MMC: FW: Shaws TCP (CMP)

Attached are our responses to the DPW's comments. Our approximate durations for each phase of work are as follows. Let me know if you would like any additional information.

Maine Medical Center Site Enabling PH2		Phase 1 Work Zone Traffic Control Plan		FIGURE <b>1A</b>
Shaw Brothers Construction, Inc. 341 Mosher Road, P.O. Box 69 Gorham, Maine 04038 (207) 839-2552				
		DRAWN: M.E.	DATE: 4/30/19	
		DESIGNED: -	SCALE: 1"=100'	
		CHECKED: -	FILE: -	
		FILE LOC: -

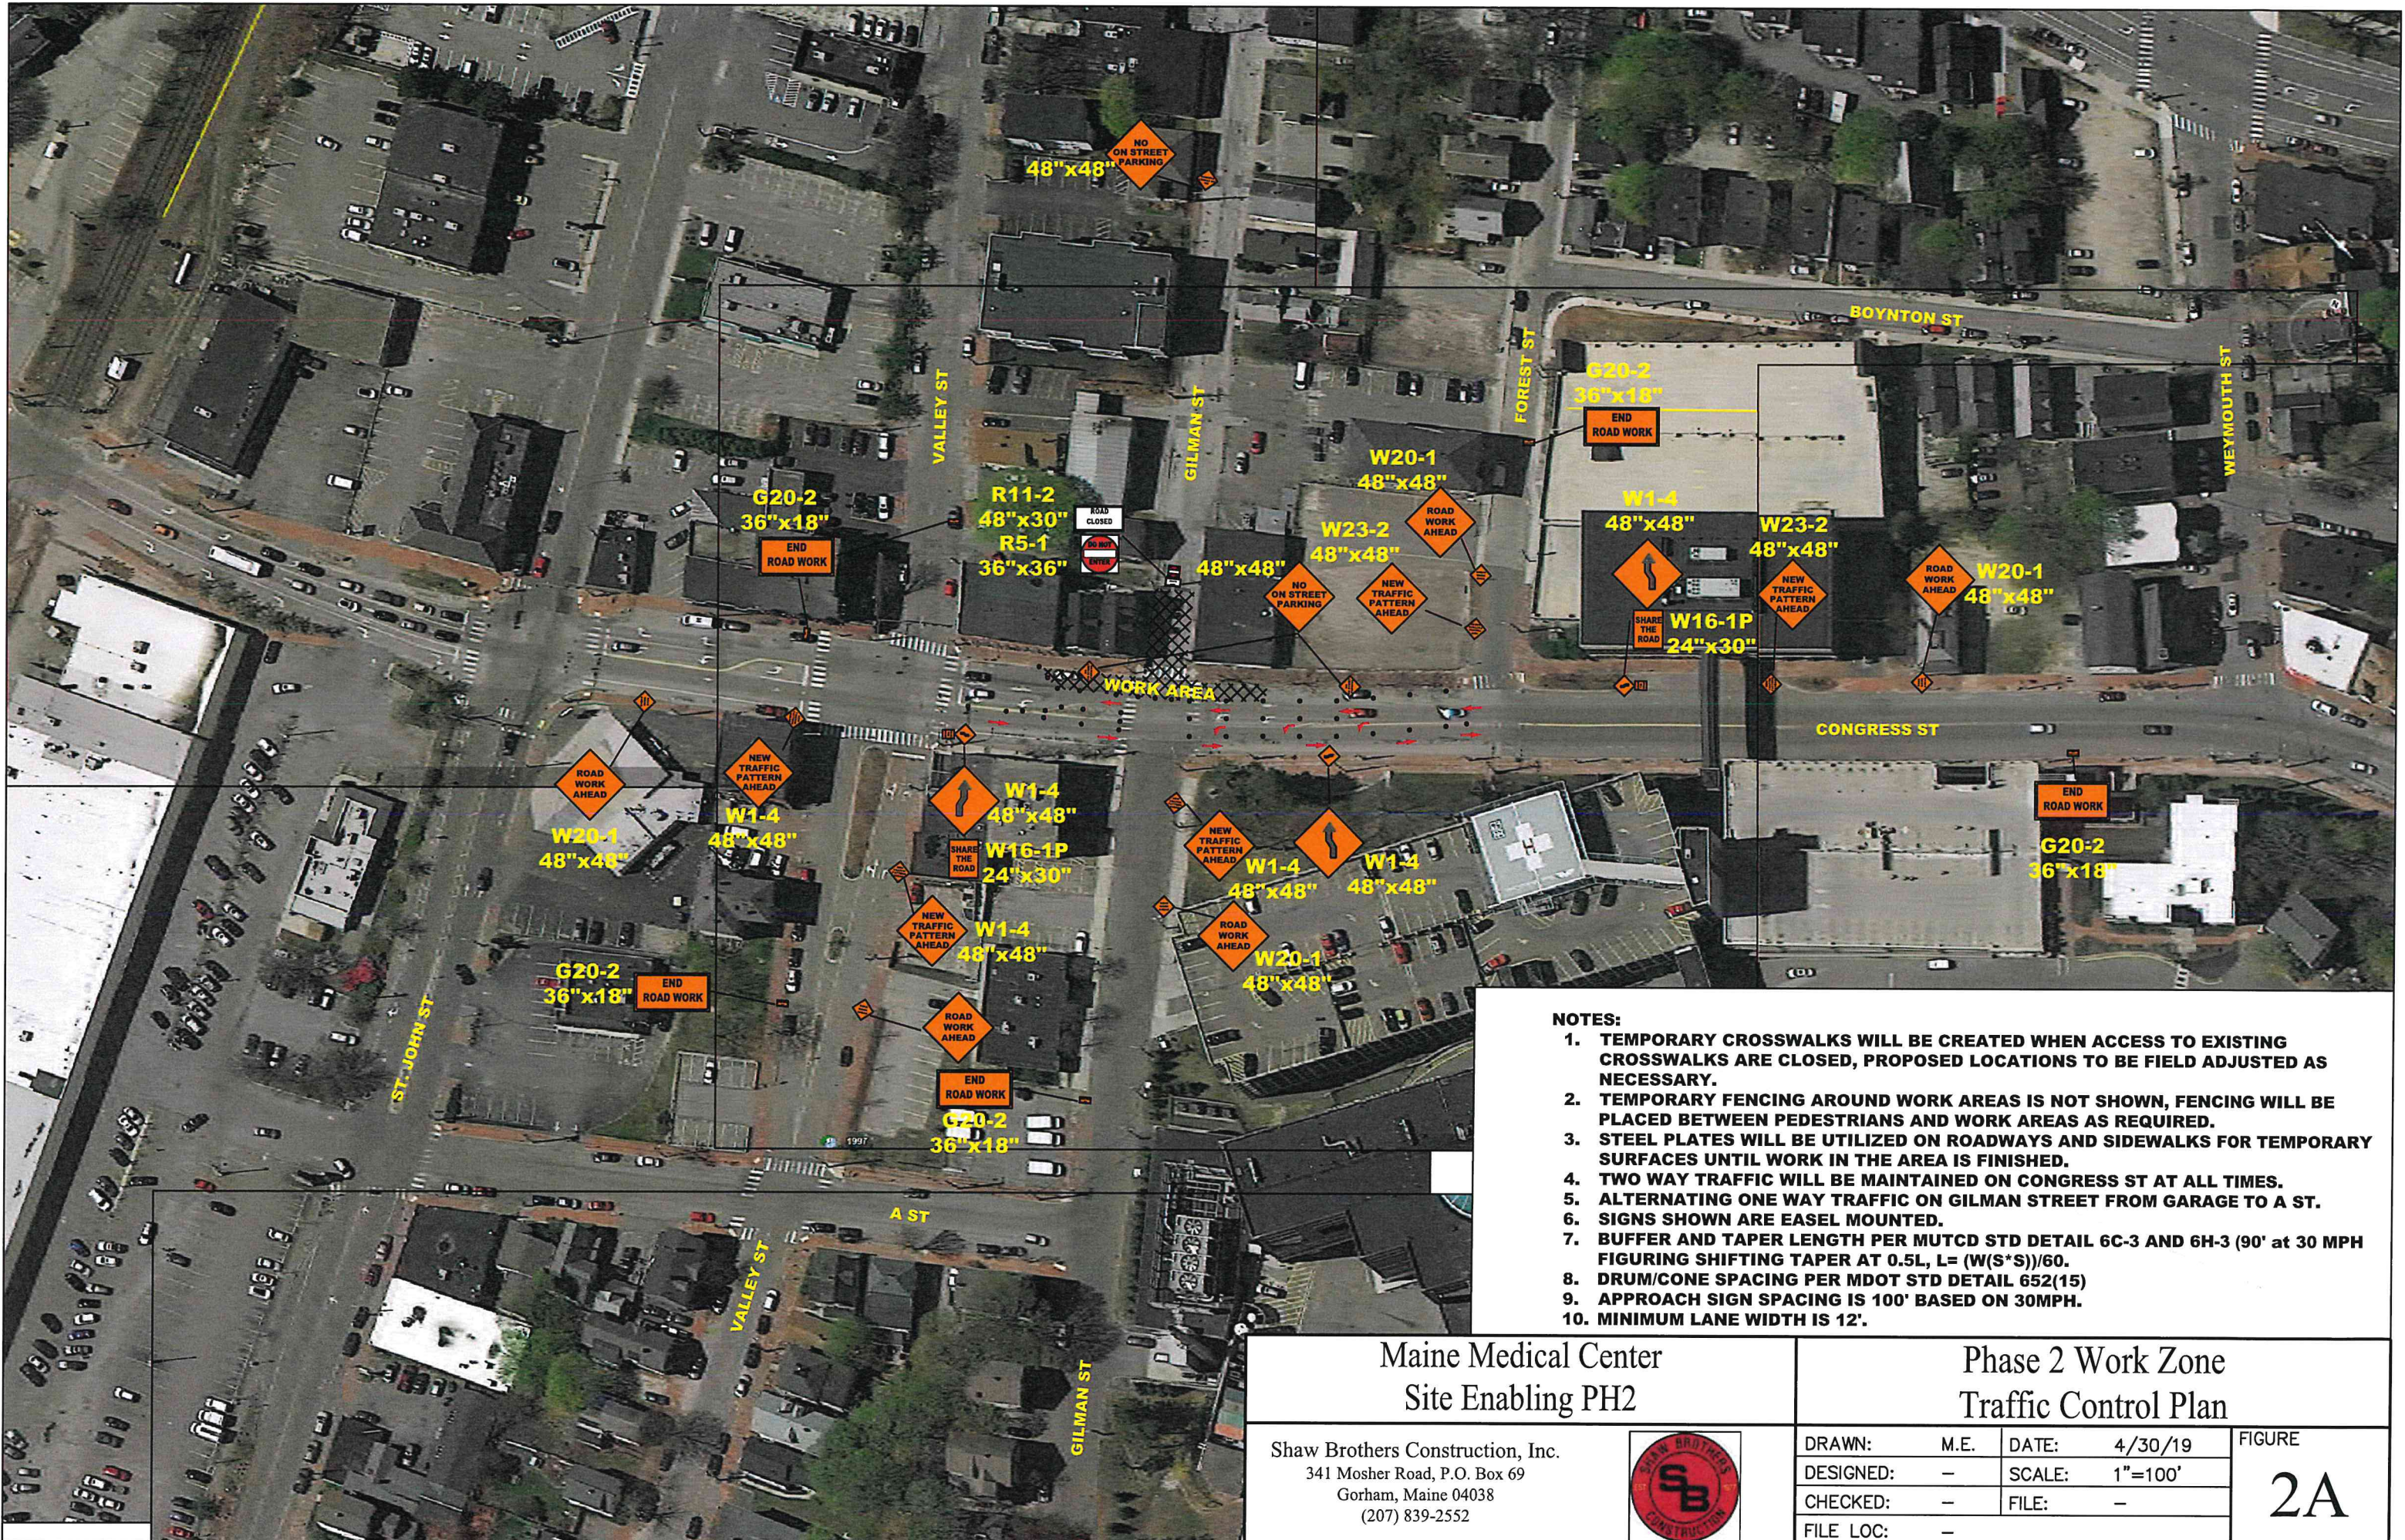
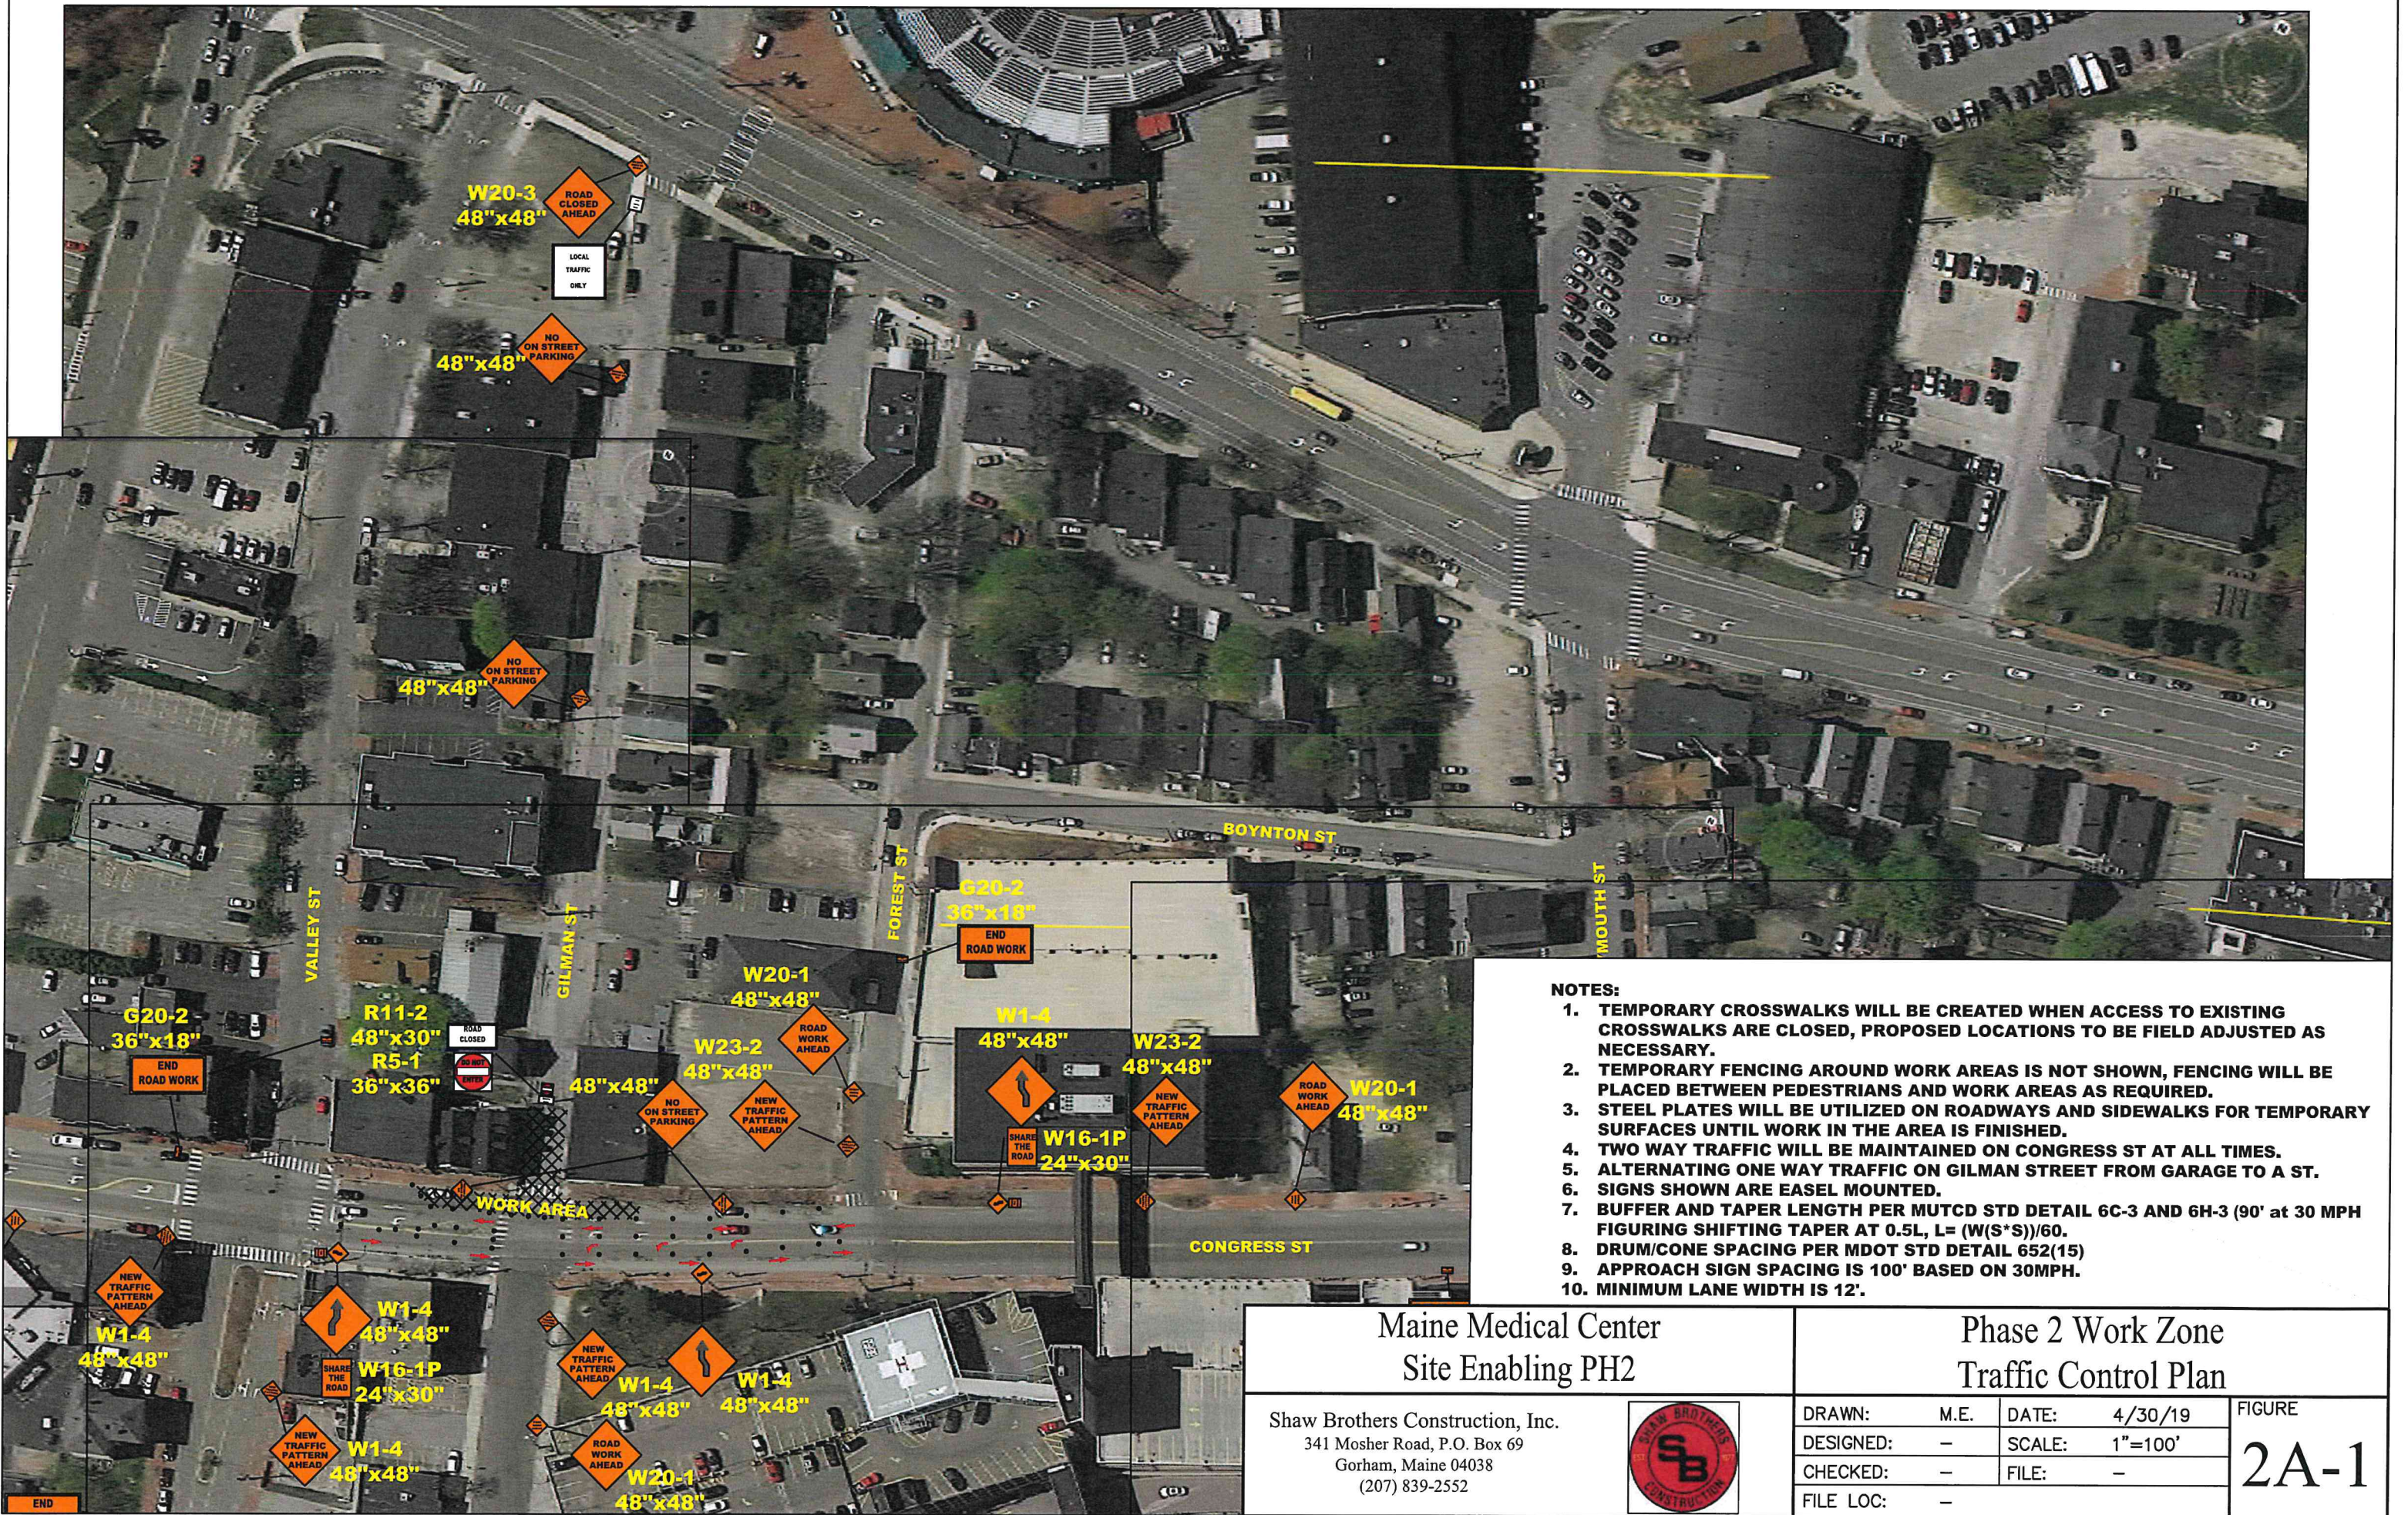
One basic comment from Tom Errico was re labeling the Shaw graphics with approximate timelines, but I don't believe this has been addressed (unless I'm missing something?). We do have timelines in the Turner documents, but these don't match up entirely with these plans. Can you guys address this quickly?

Phase #1: 3-4 weeks

Phase #2: 8-10 weeks

Phase #3: 4-6 weeks
